From: Amanda Scholes on behalf of Planning.Responses
Sent: 19 October 2018 12:10
To: Planning Scanning
Subject: FW: A/114/18/PL Broadlees, Dappers Lane, Angmering

From: Stephen Gee [REDACTED]
Sent: 19 October 2018 11:06
To: Anita Gardner; Planning.Responses
Cc: Anna Gillings; Chris Slack; Emma Patchell; James Warbey
Subject: RE: A/114/18/PL Broadlees, Dappers Lane, Angmering

Subject: A/114/18/PL Broadlees, Dappers Lane, Angmering

I write to you in relation to the proposed 70 bed care home development at the Broadlees site on Dappers Lane, Angmering. You will be aware that the site has extant planning consent for a development consisting of 53No. Care apartments (A/27/16/PL).

Appendix E – Proposed Pedestrian Infrastructure

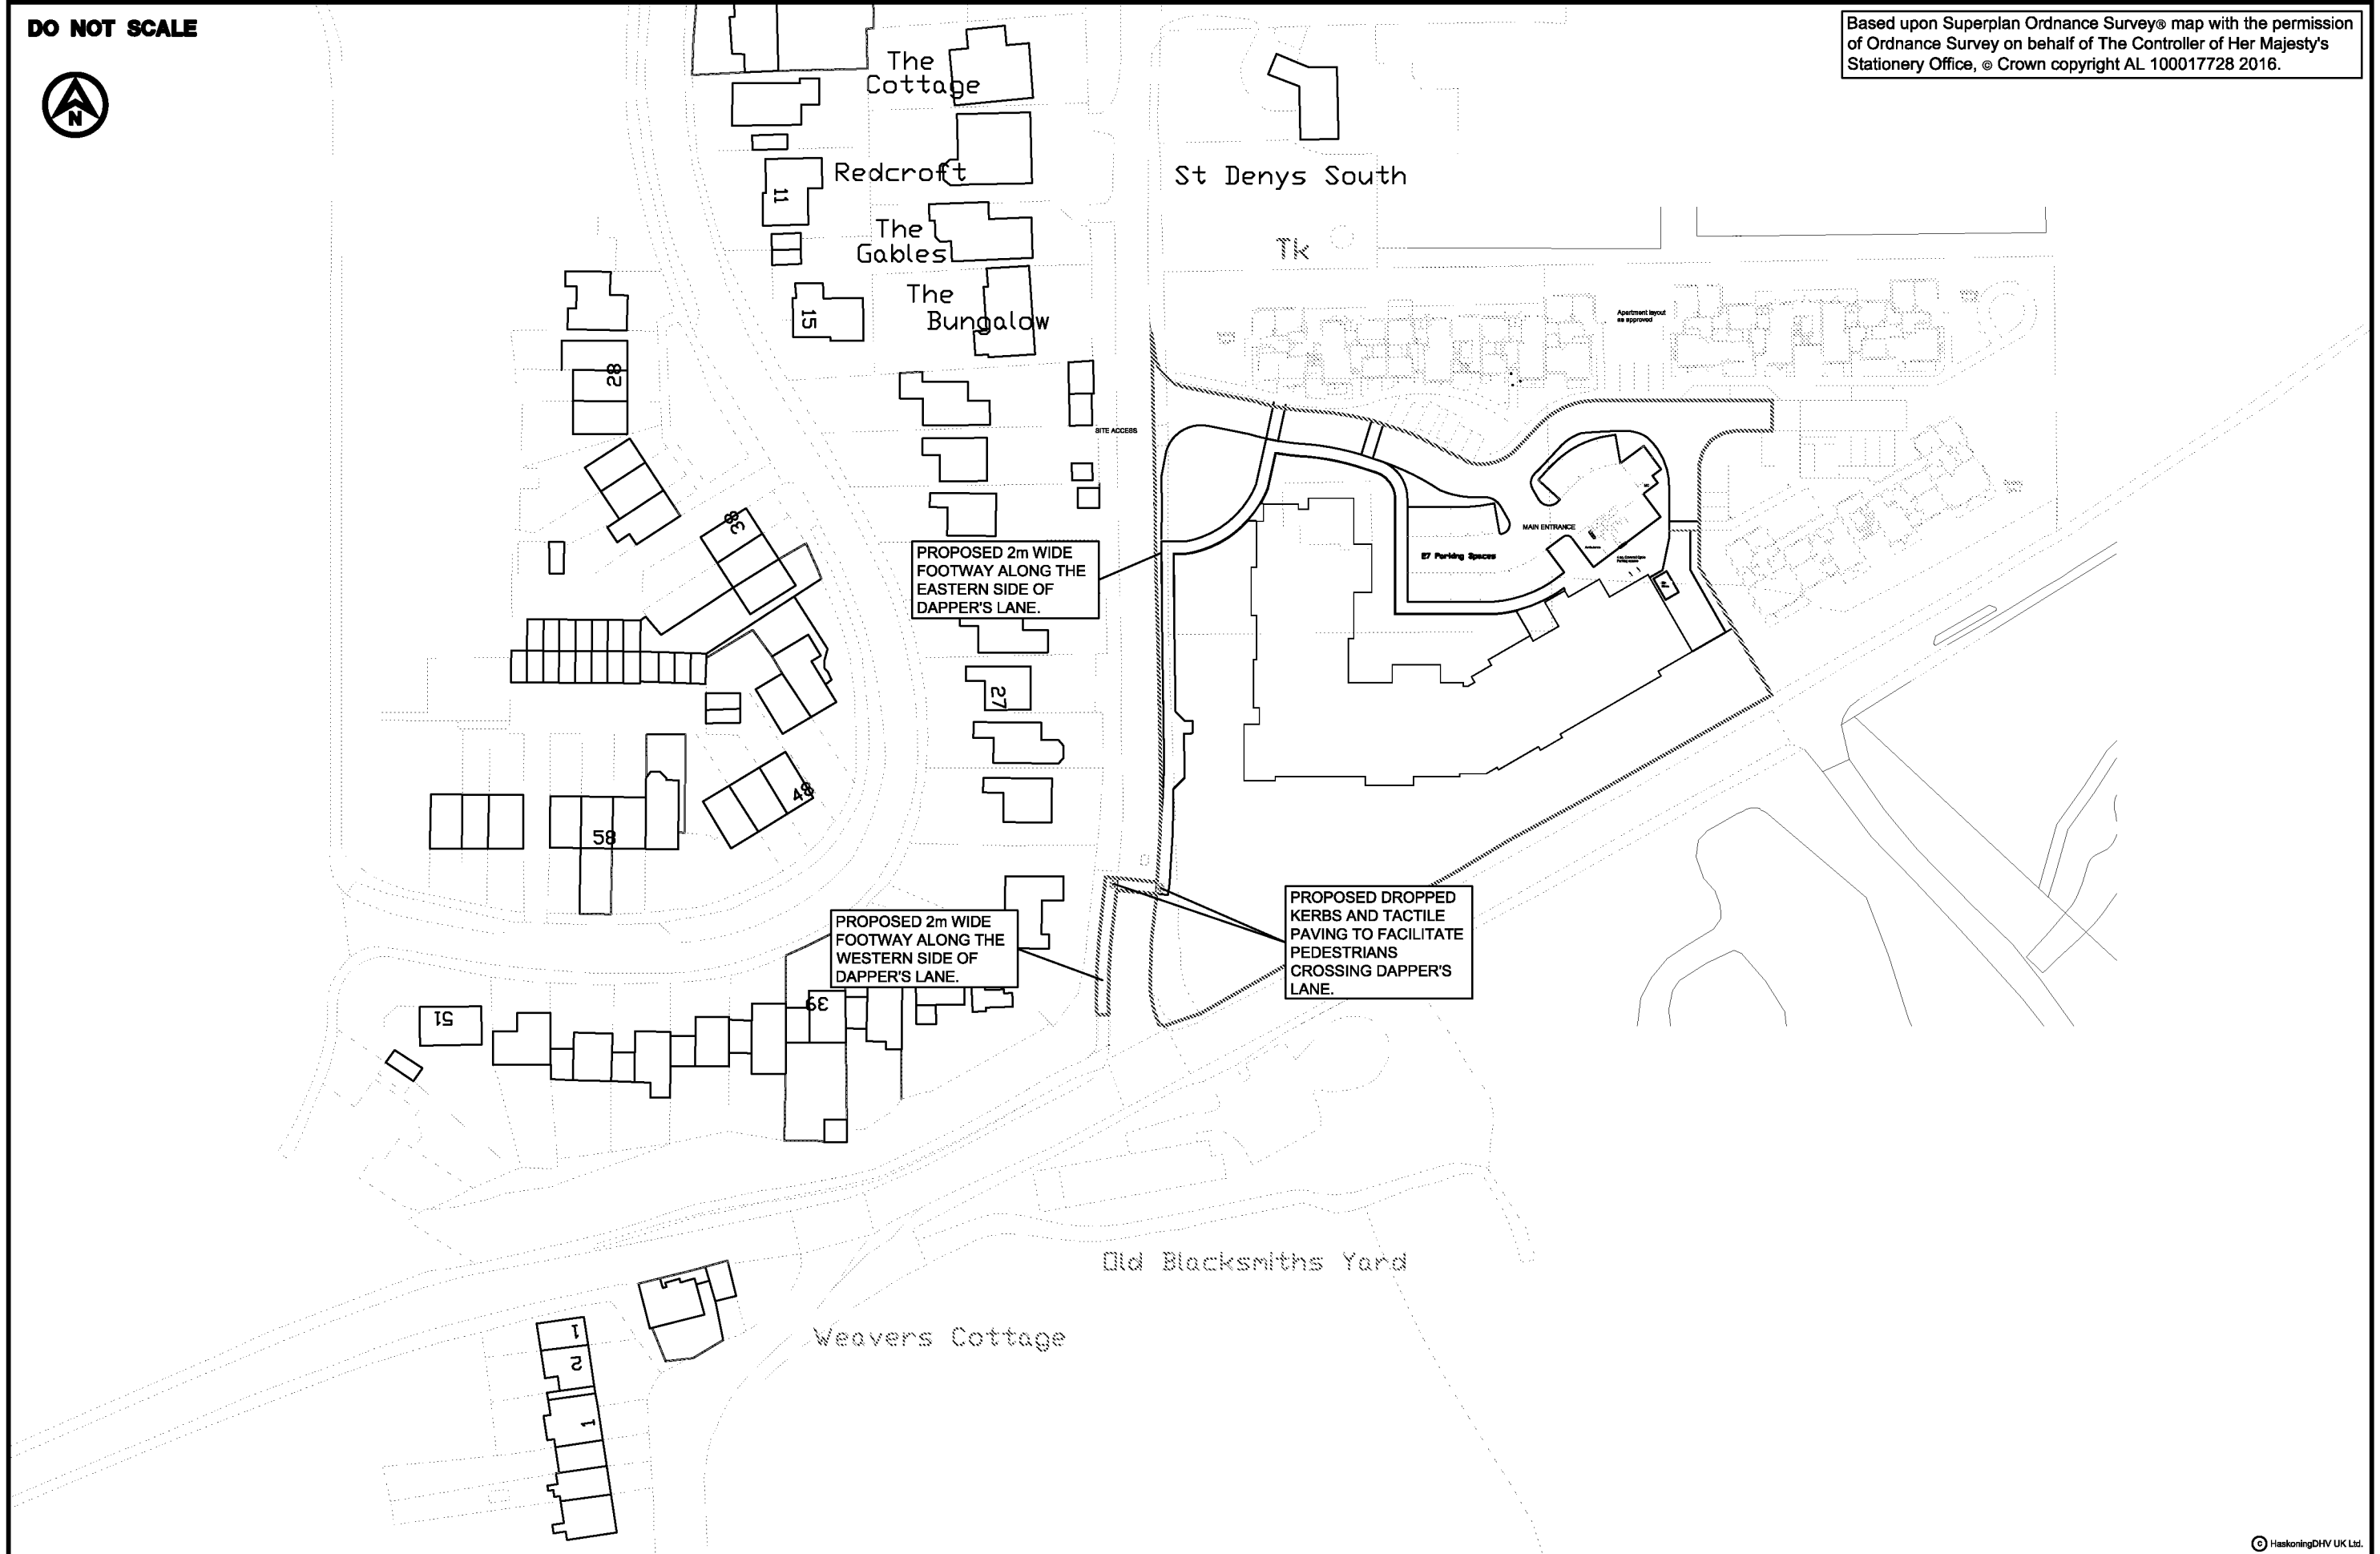
Whilst I believe the provision of a footway along Water Lane would provide some benefits for future residents and employees of the proposed development in conjunction with that proposed as part of planning apps A/99/17 and A/40/18. I am content that the provision of a footway would not be a requirement for this application or reason for refusal.

In relation to the off-site pedestrian infrastructure proposed, the construction of a footway and informal pedestrian crossing is agreed as per the extant consent and presented within attached plan **PB7693-SK01**. In your response you make reference to the adjacent planning application sites proposed by Gleeson/Rydon Homes:

*Two planning applications A/99/17 – Land South of Water Lane and A/40/18 – Land North of Water Lane are currently being considered by ADC. In combination the sites would provide a link between Dappers Lane to the north of the development to Water Lane and then onwards to the High Street and Roundstone Lane **It is recommended***

that that the application site provides a footway along Water Lane. This would reduce east to west journeys by 100m (compared to the provision anticipated as part of A/40/18).
